## URBAN DESIGN REVIEW PANEL REPORT

**Project:** 2514 – 441 Echo Drive  
**Hearing Date:** 06 March 2026, 10:30am  
**Comments Received:** 17 March 2026  
**File No.** PC2025-0290

## RESPONSE TO UDRP RECOMMENDATIONS

Project:	2514 – 441 Echo Drive	Date:	07 May 2026
Hearing Date:	06 March 2026	Pages:	-
Comments Received:	17 March 2026

**SITE PLAN**

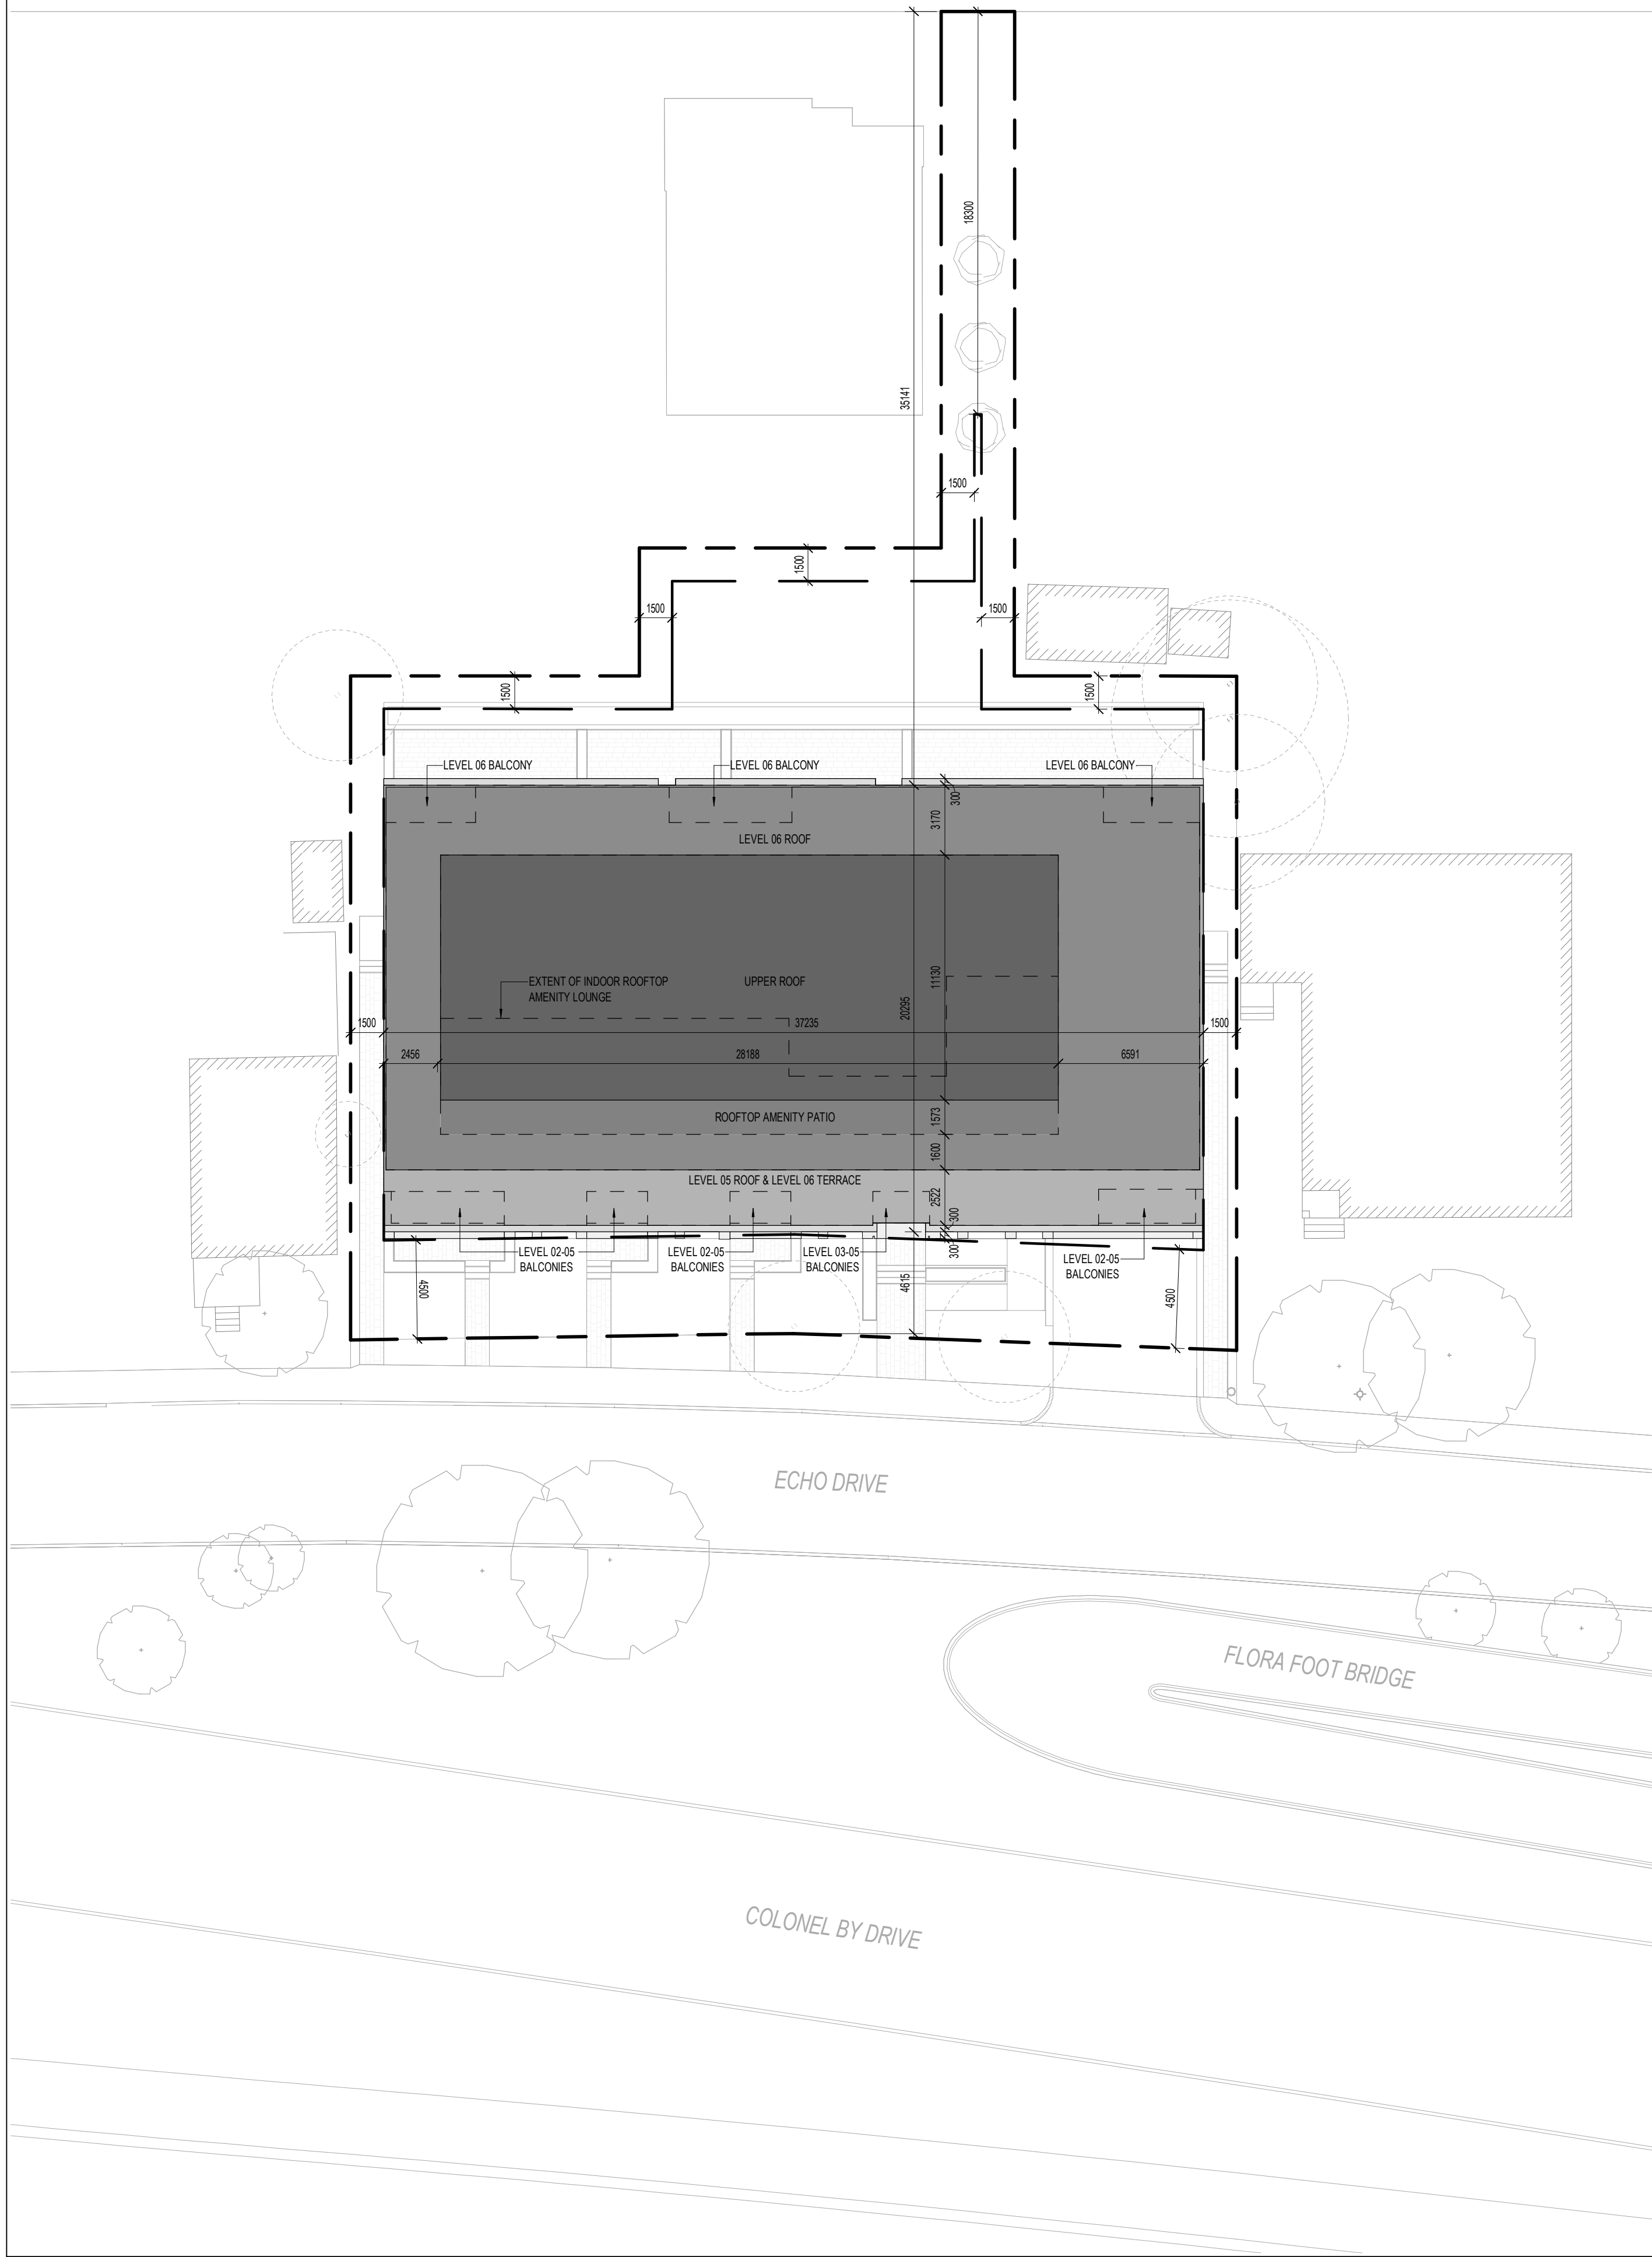
- *The Panel suggests reviewing the site design to ensure that proposed trees have access to adequate soil volumes. Where possible, trees should not be planted on structural slabs, as this can limit their long-term health and growth.*

**Noted.**
- *The Panel also noted opportunities to refine the landscape programming within the site. The rear yard currently appears largely planted, and the Panel encourages introducing small, shared amenity spaces for residents, such as seating areas, gathering spaces, or community gardening plots.*  
This comment is noted, however with the required grading for the site providing barrier-free access to this area is challenging. That said, we will continue to explore opportunities to program this area but this may be more as private amenity space instead of a communal amenity area.

**1 ROOF PLAN**  
A106 SCALE: 1 : 100

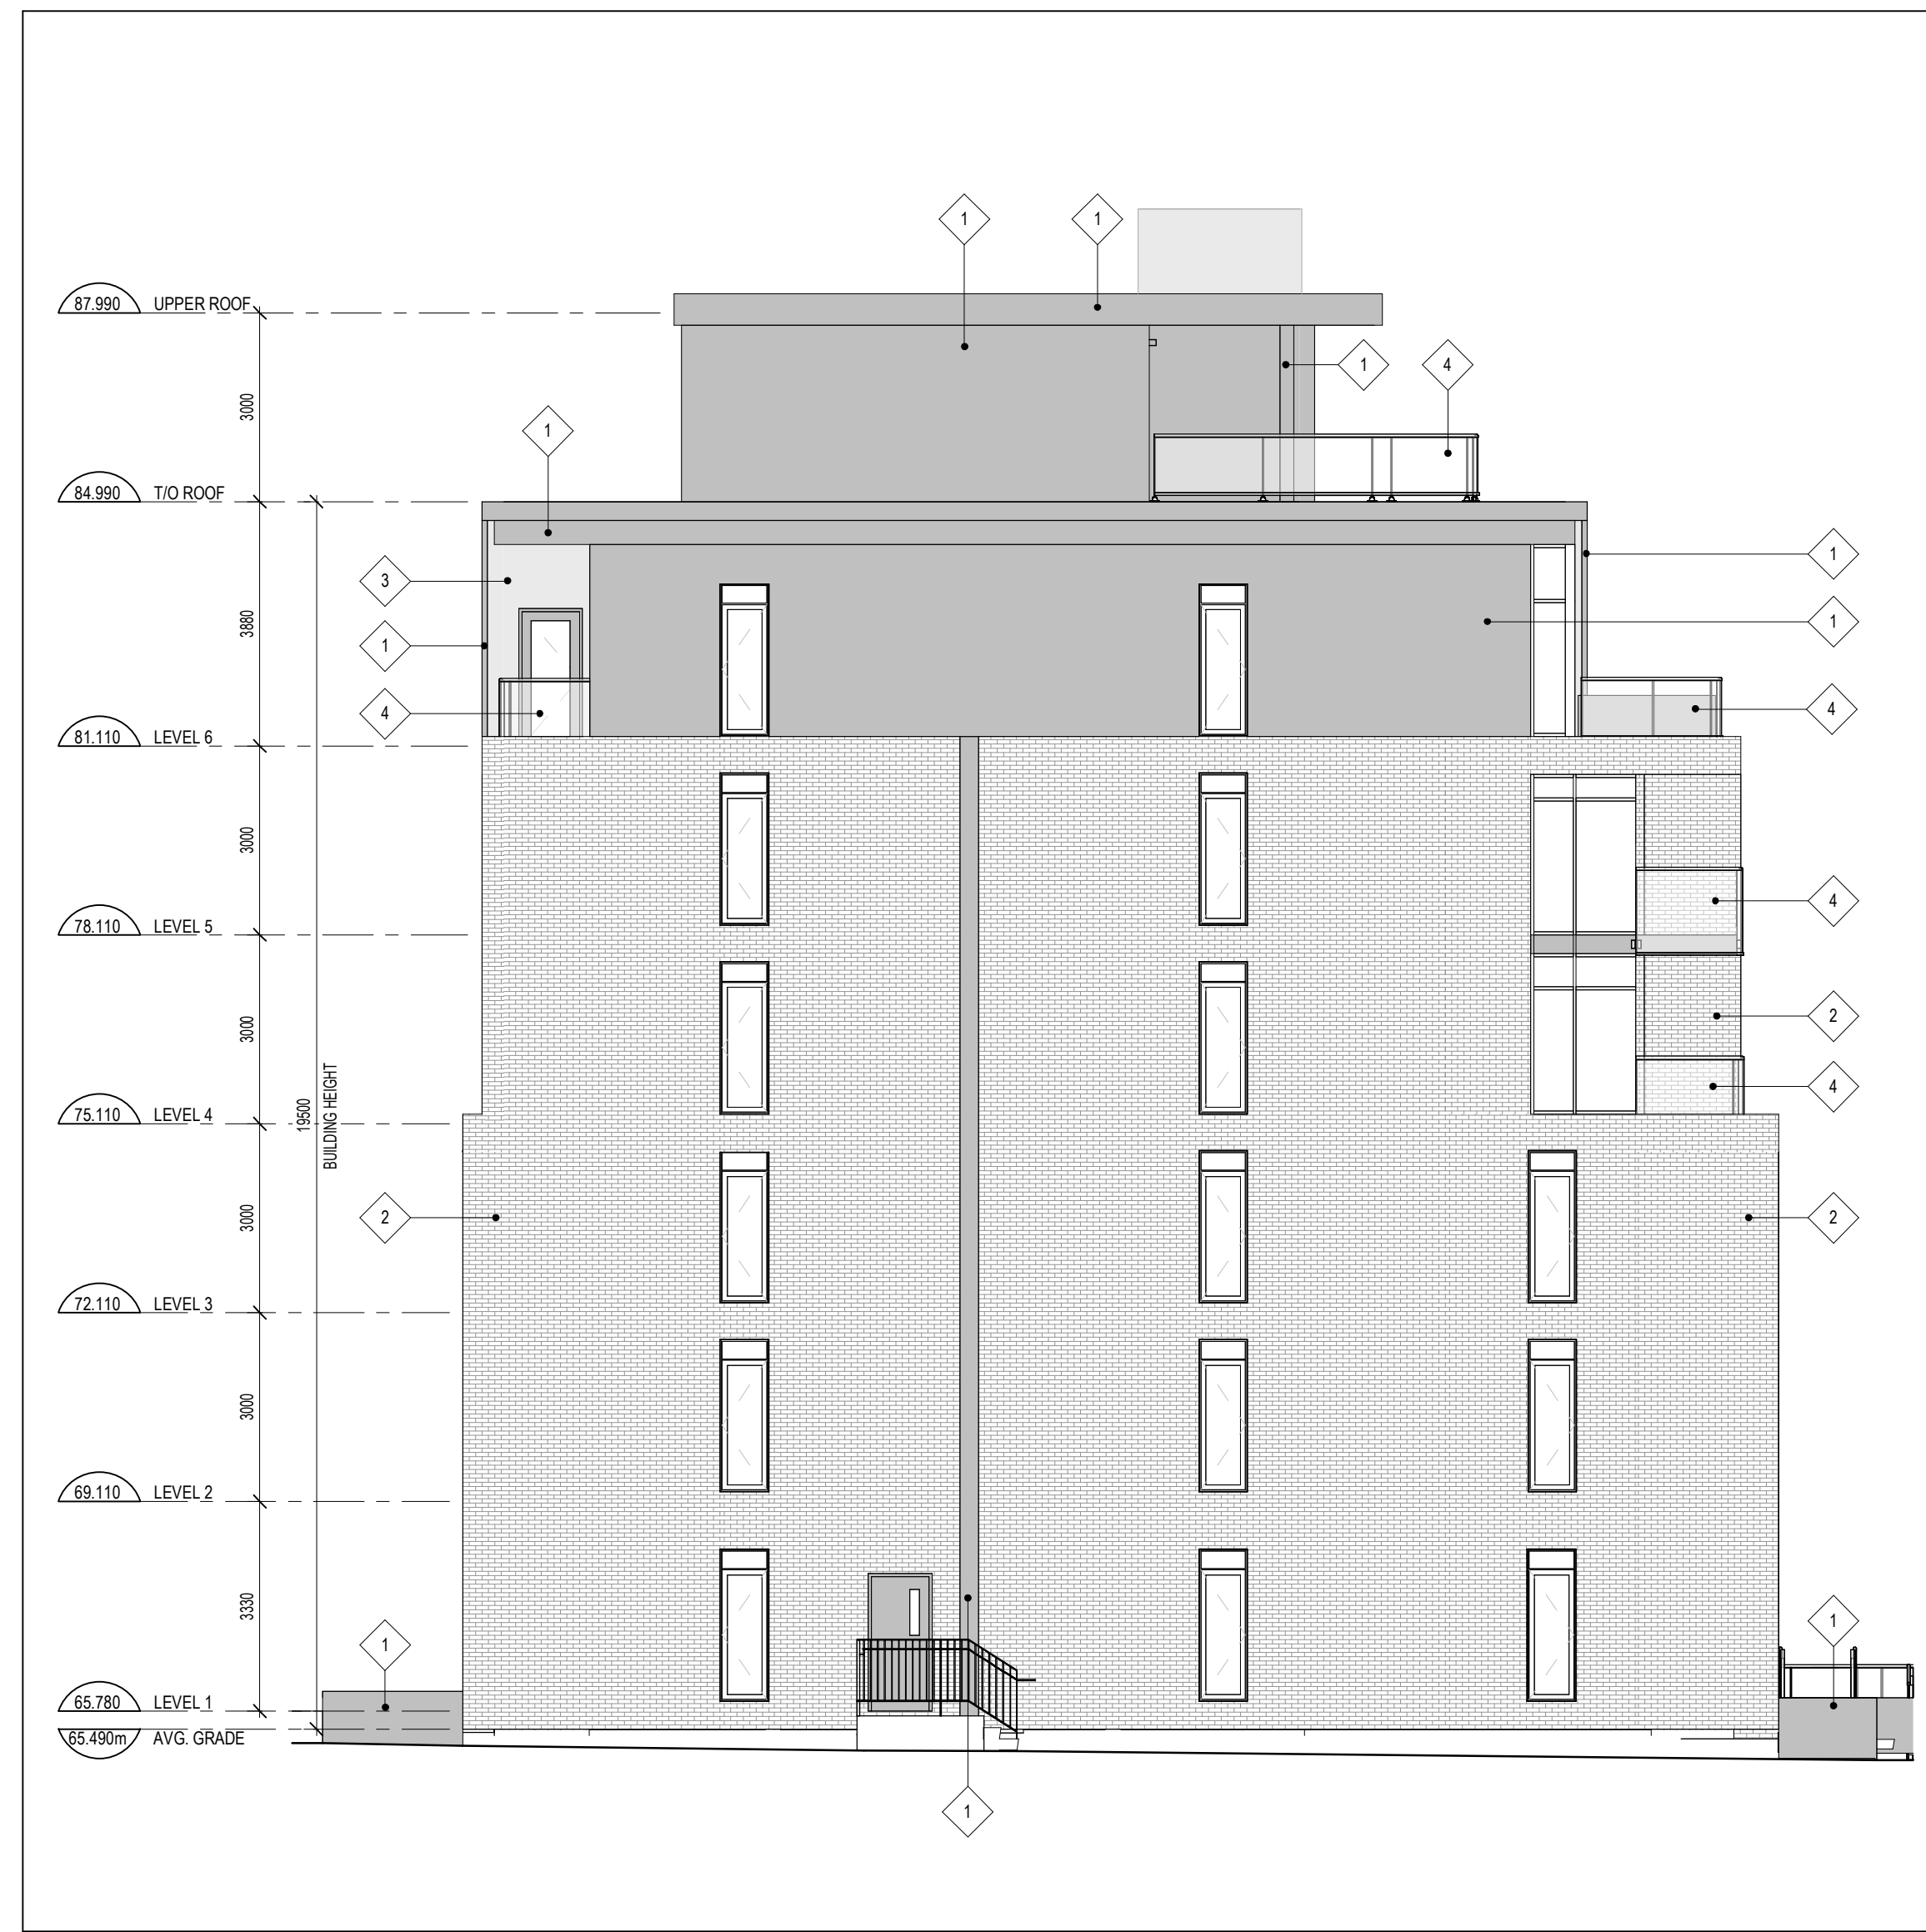
- The Panel acknowledges that this is a very handsome building. However, further refinement is suggested, particularly from a massing perspective.*

We have introduced a tripartite expression to the lower levels of the building, as suggested, please refer to the revised renderings.
- The Panel encourages simplification of the upper portions of the building so that the top levels recede visually and blend more with the sky, helping to reduce the overall perception of height and mass.*

- *The Panel also encourages simplification of architectural treatment at the top of the building.*
  - *Reducing the visual emphasis of the roof-level elements and avoiding strong projecting forms may help diminish the apparent height and mass of the building, particularly when viewed from the bridge and along the Canal corridor.*

We understand this comment to be in relation to the size of the upper levels of the building. We have made adjustments to the massing of the roof level which includes moving the enclosure further away from the interior side yards and a lowering of the overall height of the rooftop enclosure. We feel that these changes will improve the massing of the project and transition into the neighborhood. appreciate the Panel's support of the project.
- The Panel expresses concern relates to the side yard setbacks, particularly along the north side and south sides above the 5th floor. The Panel recommends introducing greater setbacks on the top floors along the side of the building to reduce the perceived mass and address the proximity to adjacent buildings.*

The articulation of the upper levels of the building has been simplified as suggested, please refer to the revised renderings.
- The Panel also emphasizes the importance of integrating development with the existing canal landscape and heritage setting.*

The articulation of the upper levels of the building has been simplified as suggested, please refer to the revised renderings.
